**WEST SUSSEX COUNTY COUNCIL
INFRASTRUCTURE CONSULTATION**

SUBJECT: AL/91/08/ - Conversion of redundant farm building to 1 x residential unit

Barn to the West of, The Bungalow, Sack Lane, Lidsey, West Sussex

Rev A		Roof plan added		nov 08	
PROJECT		Conversion of existing farm building at Sack Lane Lidsey			
DRAWING		Proposed Plans and Elevations			
SCALE	DATE	DWG. No.	REV		
1:100	May 08	07 / 87 / 01	A		
DRAWN	CHECKED

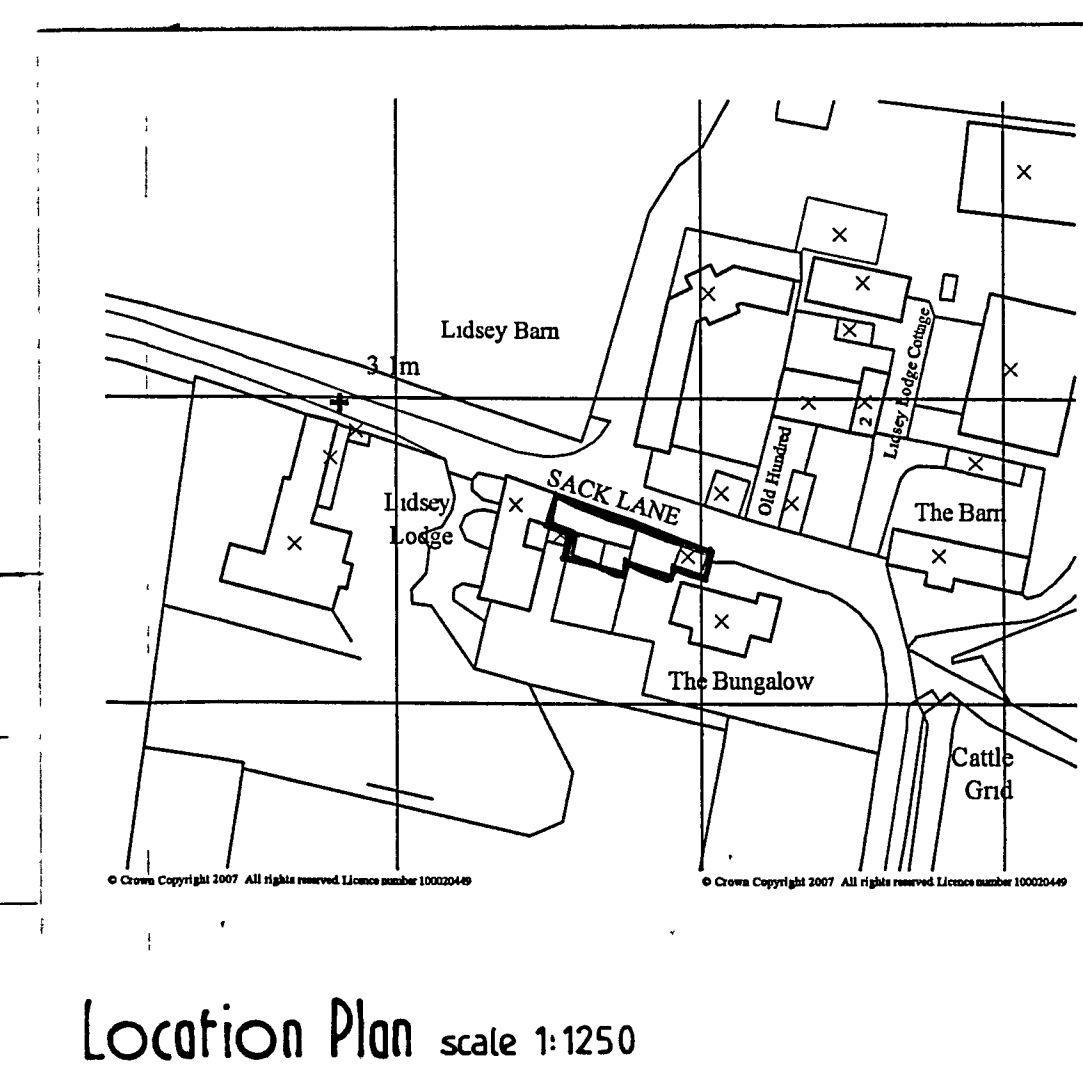
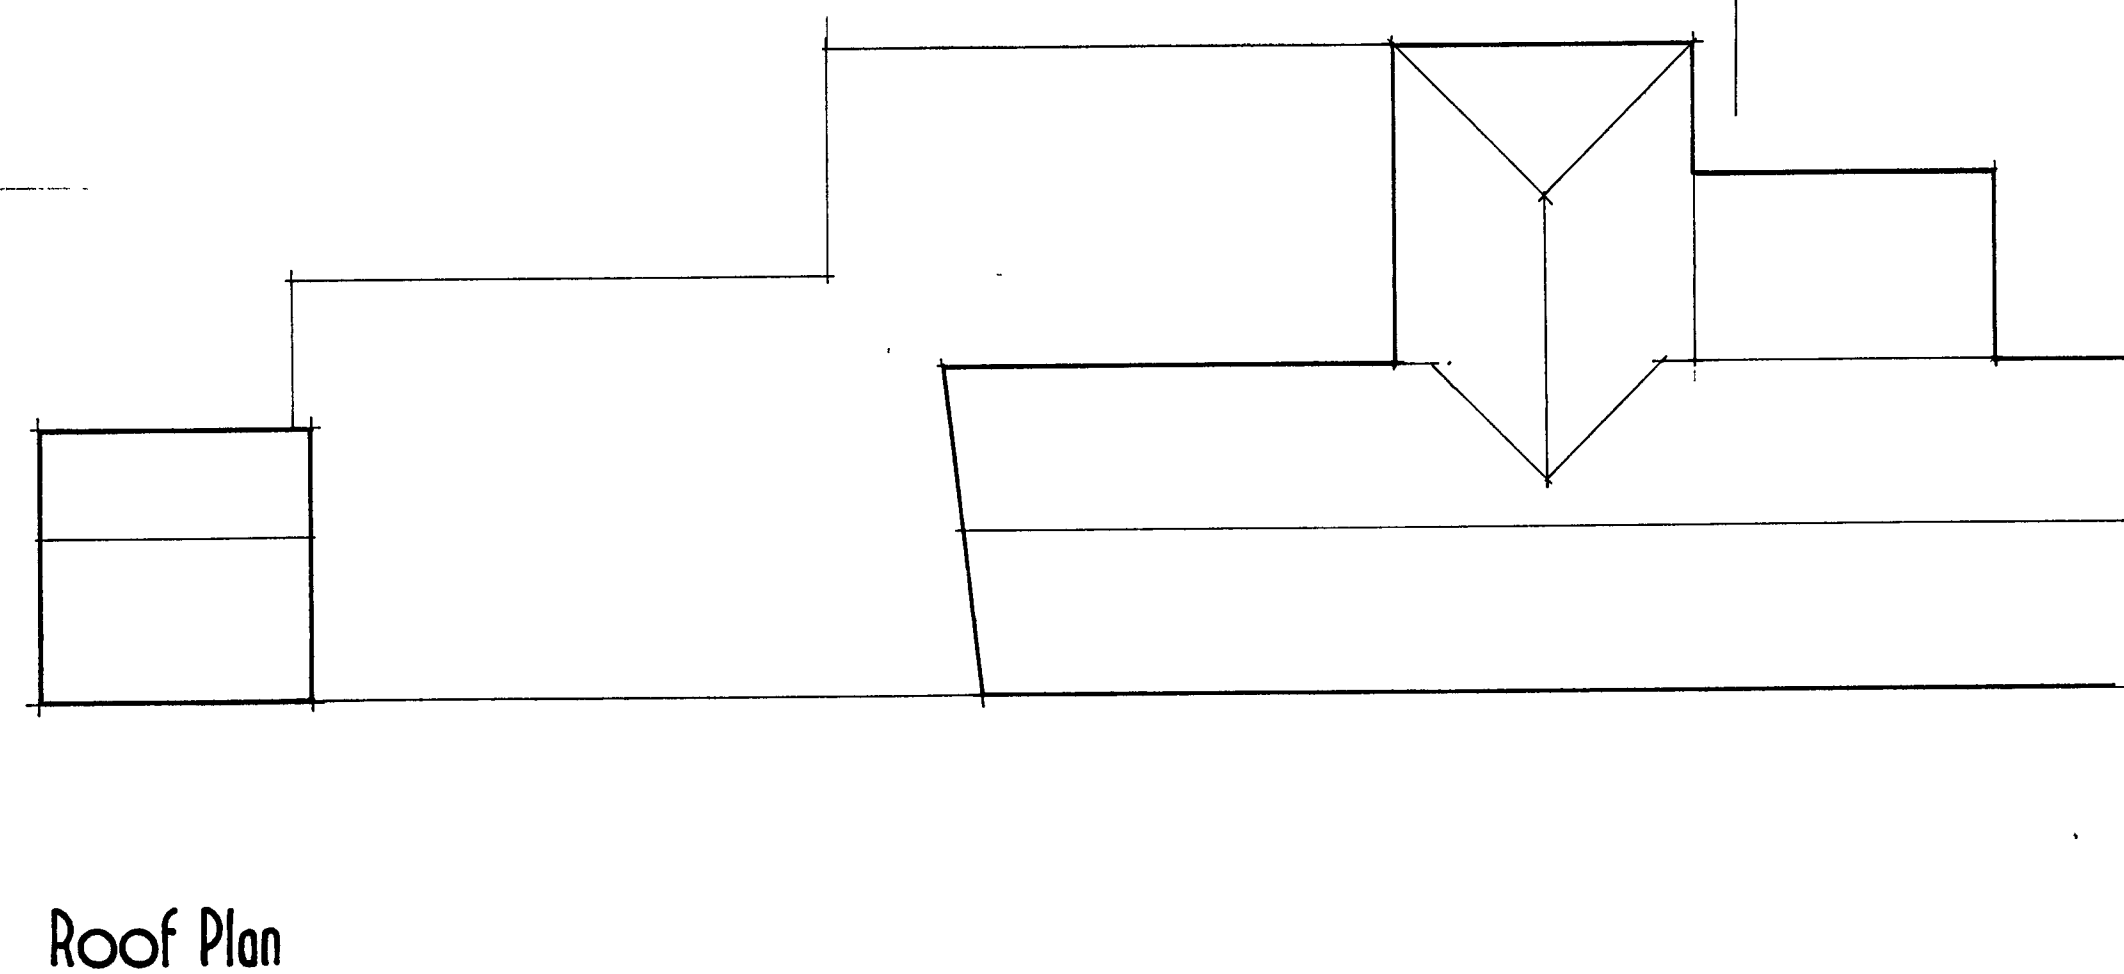
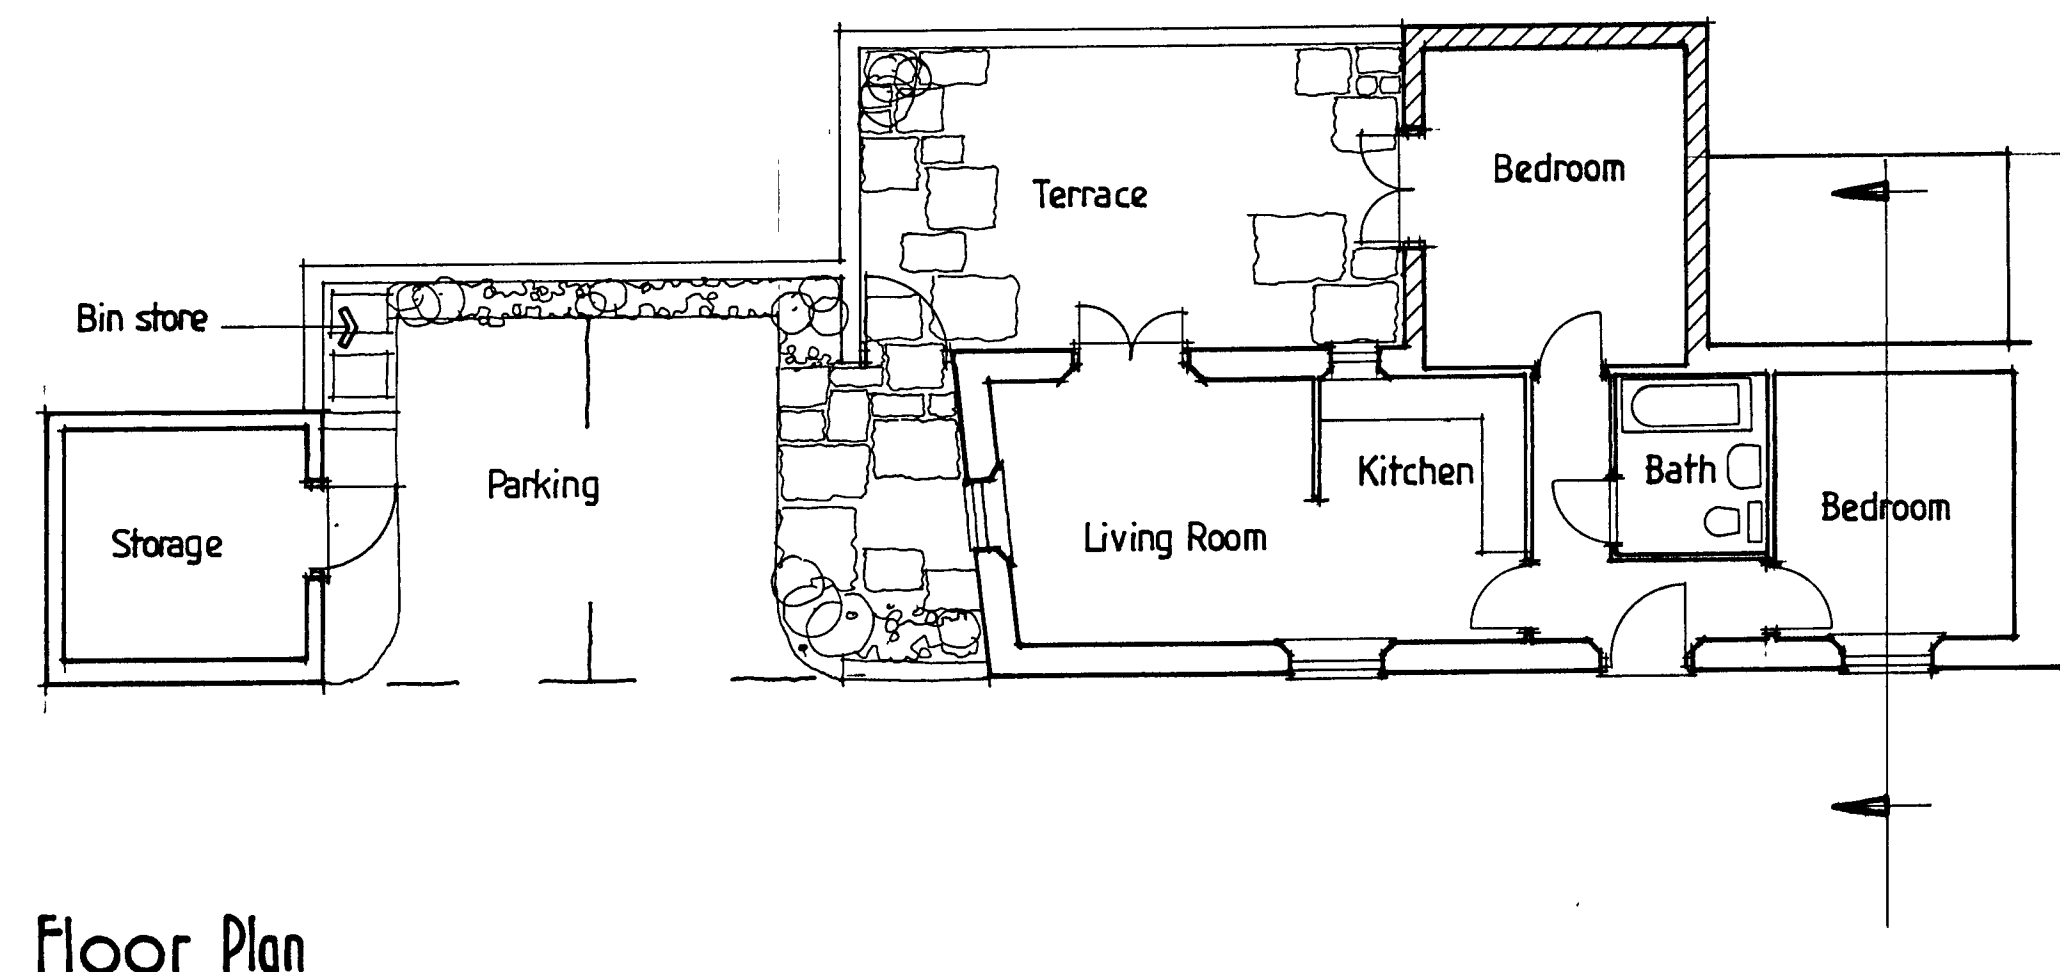
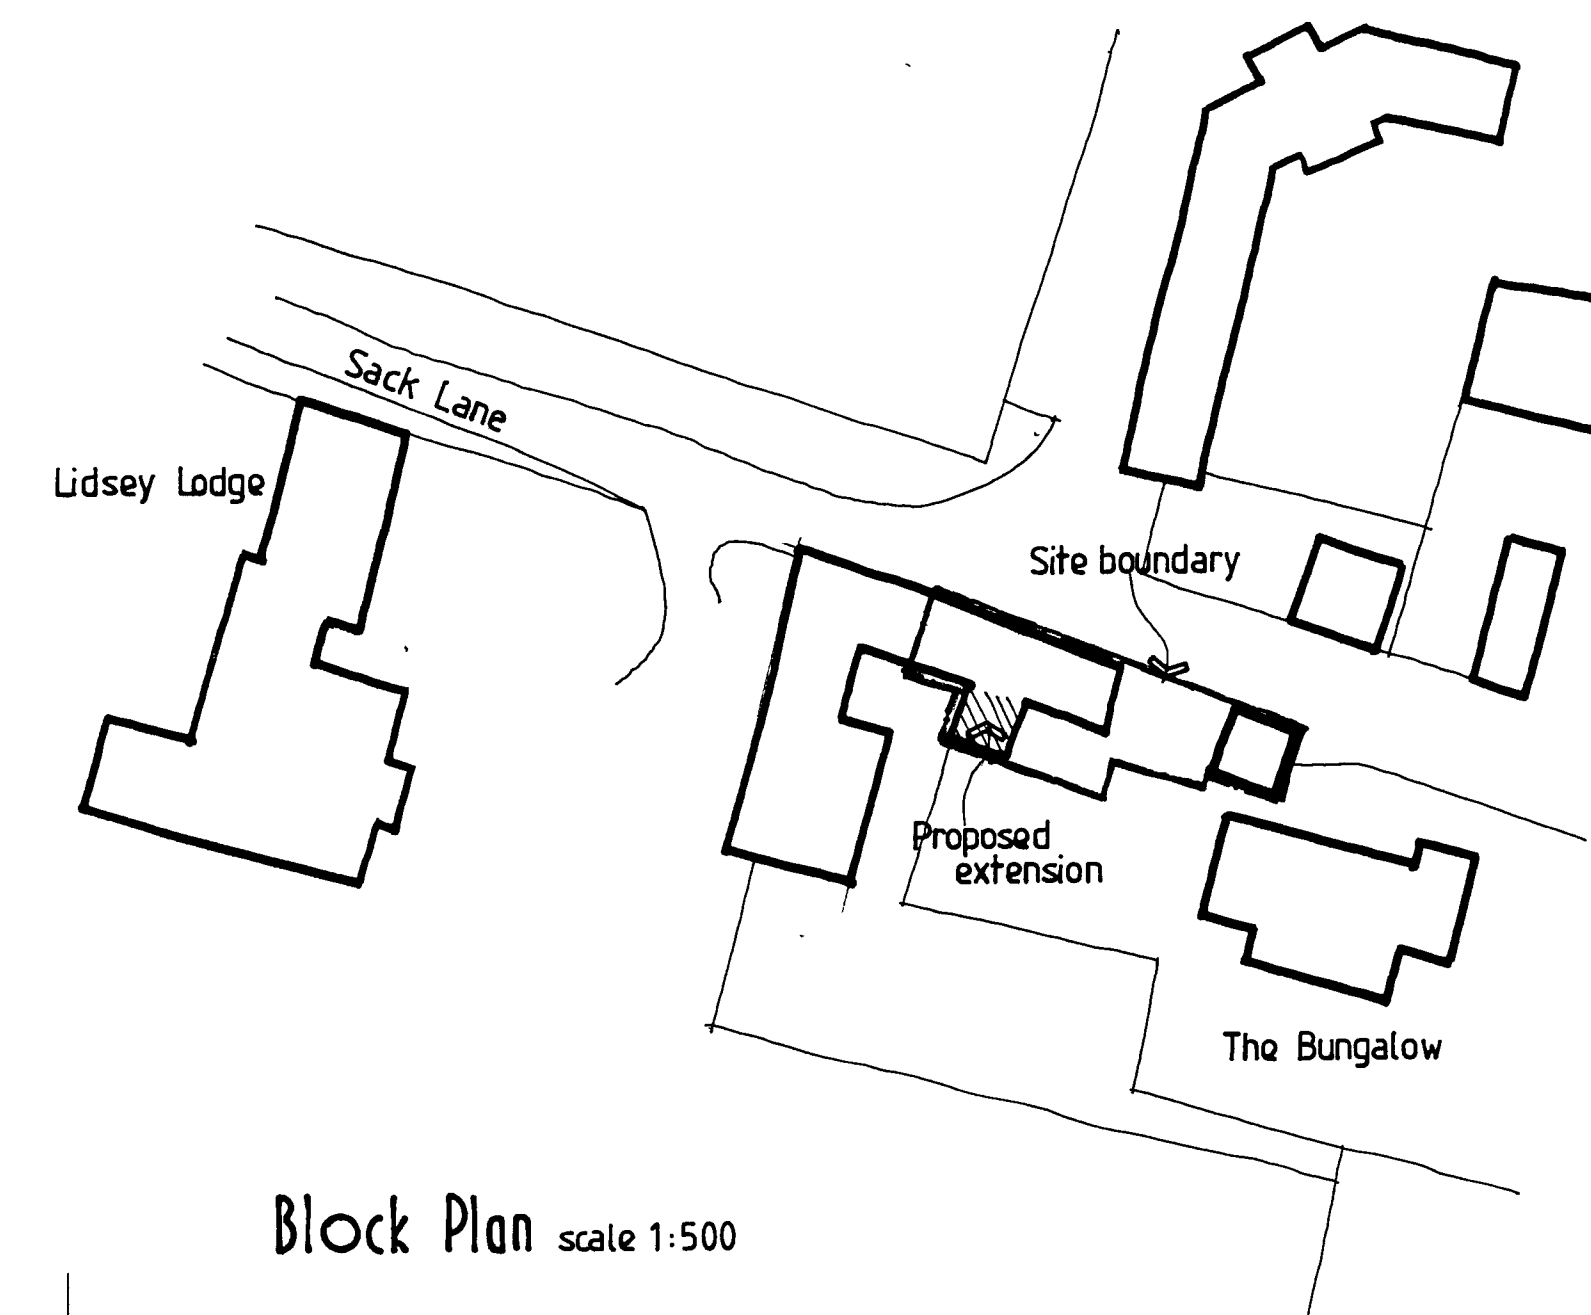
The proposal is for the conversion of the redundant farm building to form a residential unit with access onto Sack Lane via an existing access point. Vehicular parking is within the WSCC maximum car parking standards. The applicant should ensure that there is secure and covered cycle parking within the property prior to any occupation. Cycle parking should equate to one cycle per bedroom.

From an inspection of the plans alone, there is no apparent visibility issue at the point of access onto Sack Lane. In principle, it is unlikely that there would be any issues with this proposal. A number of dwellings are already served from Sack Lane and whilst a small increase in vehicle movements may occur, it is unlikely that any adverse impacts will result from this proposal.

No dwelling, hereby approved, shall be occupied until covered secure cycle parking spaces have been provided in accordance with a detailed construction plan to be submitted to and approved by the planning authority.
